**Application for Development Consent Order- Construction and operation of a combined heat and power (CHP) plan ('K4') to supply electricity and steam to the Kemsley Paper Mill in Sittingbourne, Kent.**

**Response to further information requested by the Examining Authority**

**EN010090: The Kemsley Mill K4 Combined Heat and Power Generating Station  
Environment Agency's response to the Examining Authority's Request for further information**

Appendix 5.3: Stack Height Determination

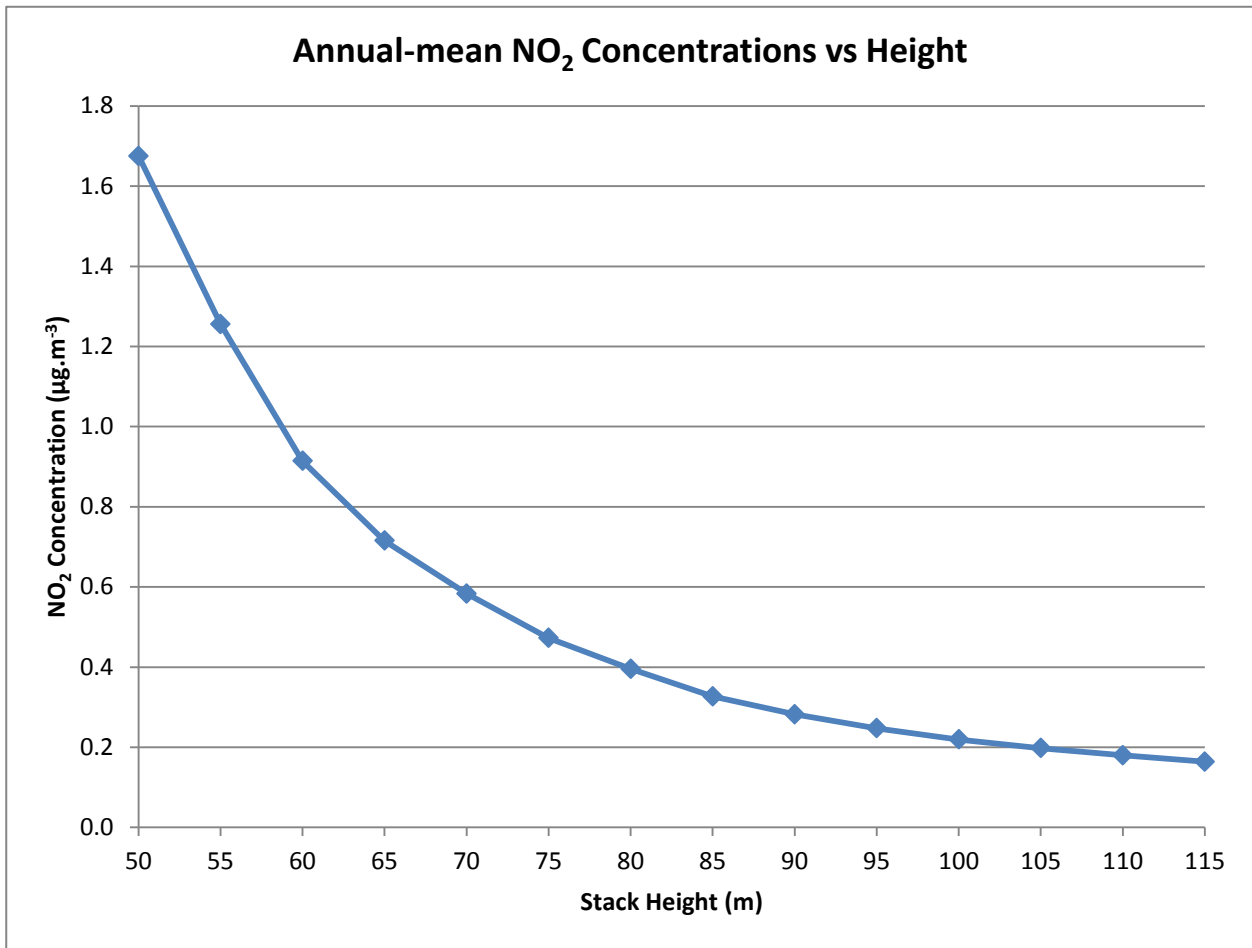
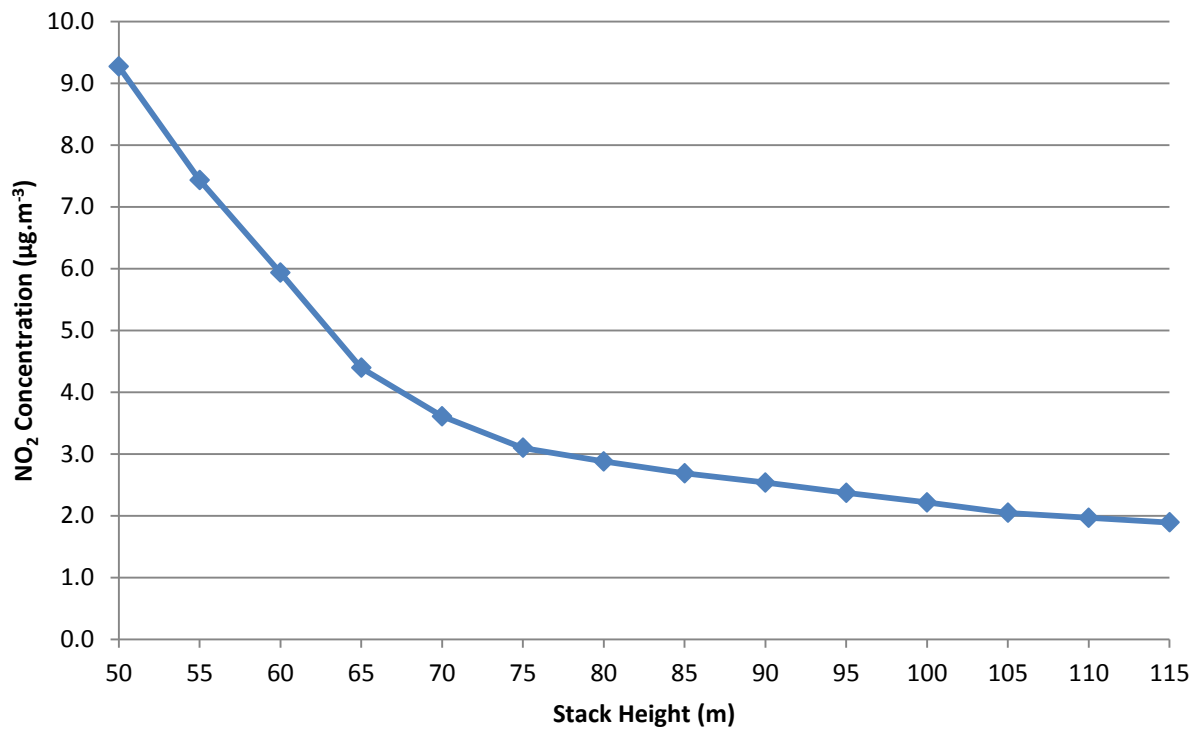
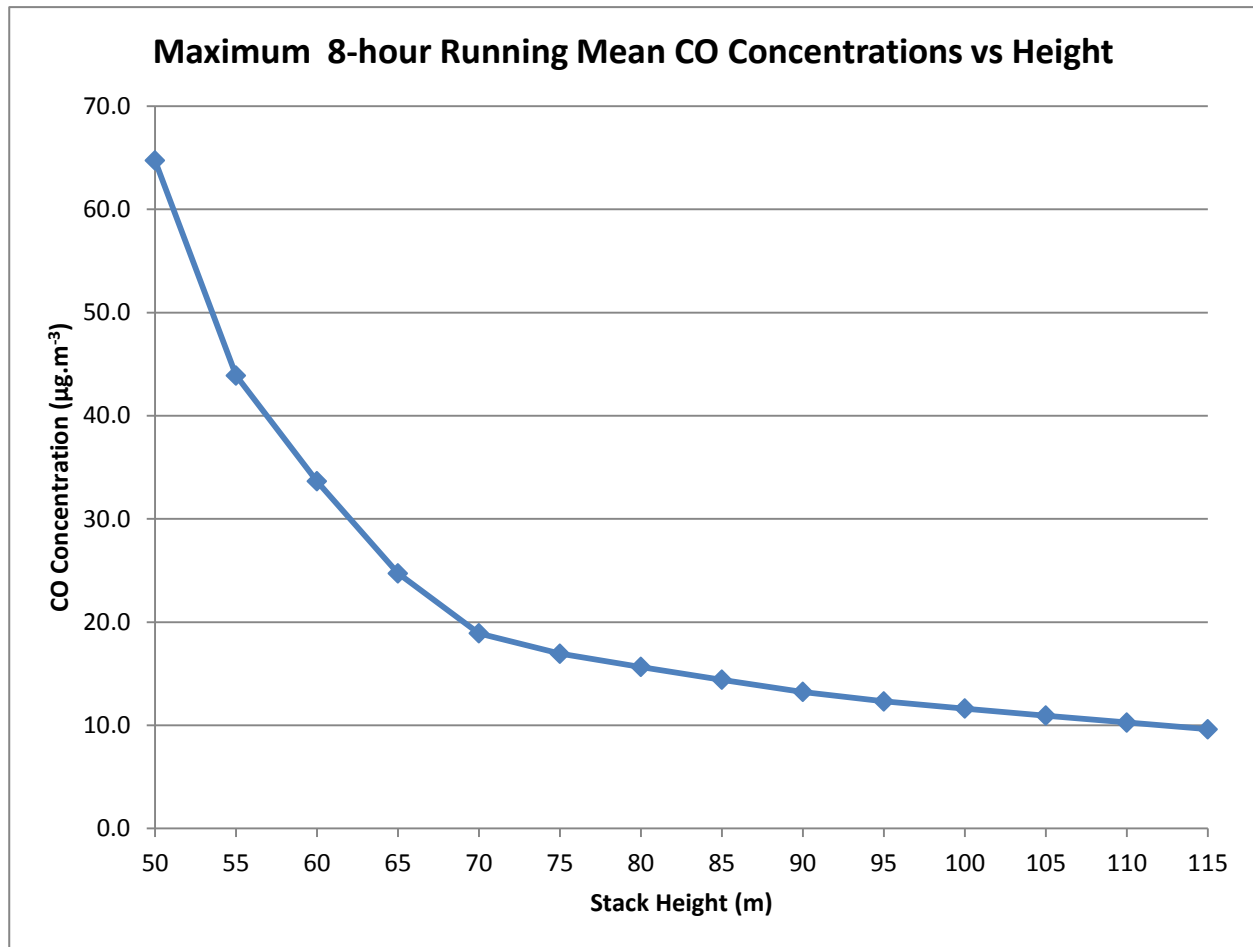
<b>Q1.1.8</b>	Applicant	Table 2.1 of the ES [APP-008] (page 2-4)	The applicant will need to demonstrate they are providing sufficient effective

Ref No.	Respondent	Question	Environment Agency response
	Environment Agency	<p>indicates a minimum stack height of 75m although it is described in the table as a 70m high stack, which is consistent with Requirement (R) R5(4) Table 1 (1e) of the dDCO, which indicates a maximum height of 70m. Table 2.1 also shows the package boiler stack as having a minimum height of 35m, in contrast to Table 1 1(j) of the dDCO which shows this as the maximum height.</p> <p>Please could the Applicant explain these apparent discrepancies?</p> <p>In addition, please explain the reference to a 75m stack height in the table following paragraph 2.11.13 of the ES (also identified as Table 2.1) and why the height of 70m is proposed. The Stack Height Determination [APP-025] concludes that a suitable stack height for the assessment is considered to be 70m. There appears to have been no assessment of stack width/diameter.</p> <p>Please can the Applicant explain how the maximum diameter of the stacks was determined.</p> <p>Is it necessary to provide flexibility and is there any possibility of the proposed heights changing in response to further design work?</p> <p>Could the Applicant and the EA please comment on how a variation would be dealt with through the DCO and environmental</p>	<p>stack height to ensure adequate dispersion of air pollutants. Emissions of air pollutants will be lower than the current K1 permit allows so a lower stack than currently used on the K1 plant may be permissible. However since the K1 plant has been permitted additional sources of NOx have been permitted in the Kemsley / Ridham area which need to be taken into consideration by the Applicant's air dispersion model.</p> <p>We are unable to comment on the proposed stack height in advance of a permit application. During the determination of the application, we would audit the Applicant's approach to air modelling. If we consider the proposed effective stack height is insufficient to afford suitable environmental protection we would require the Applicant to increase the effective stack height, or refuse the application.</p>
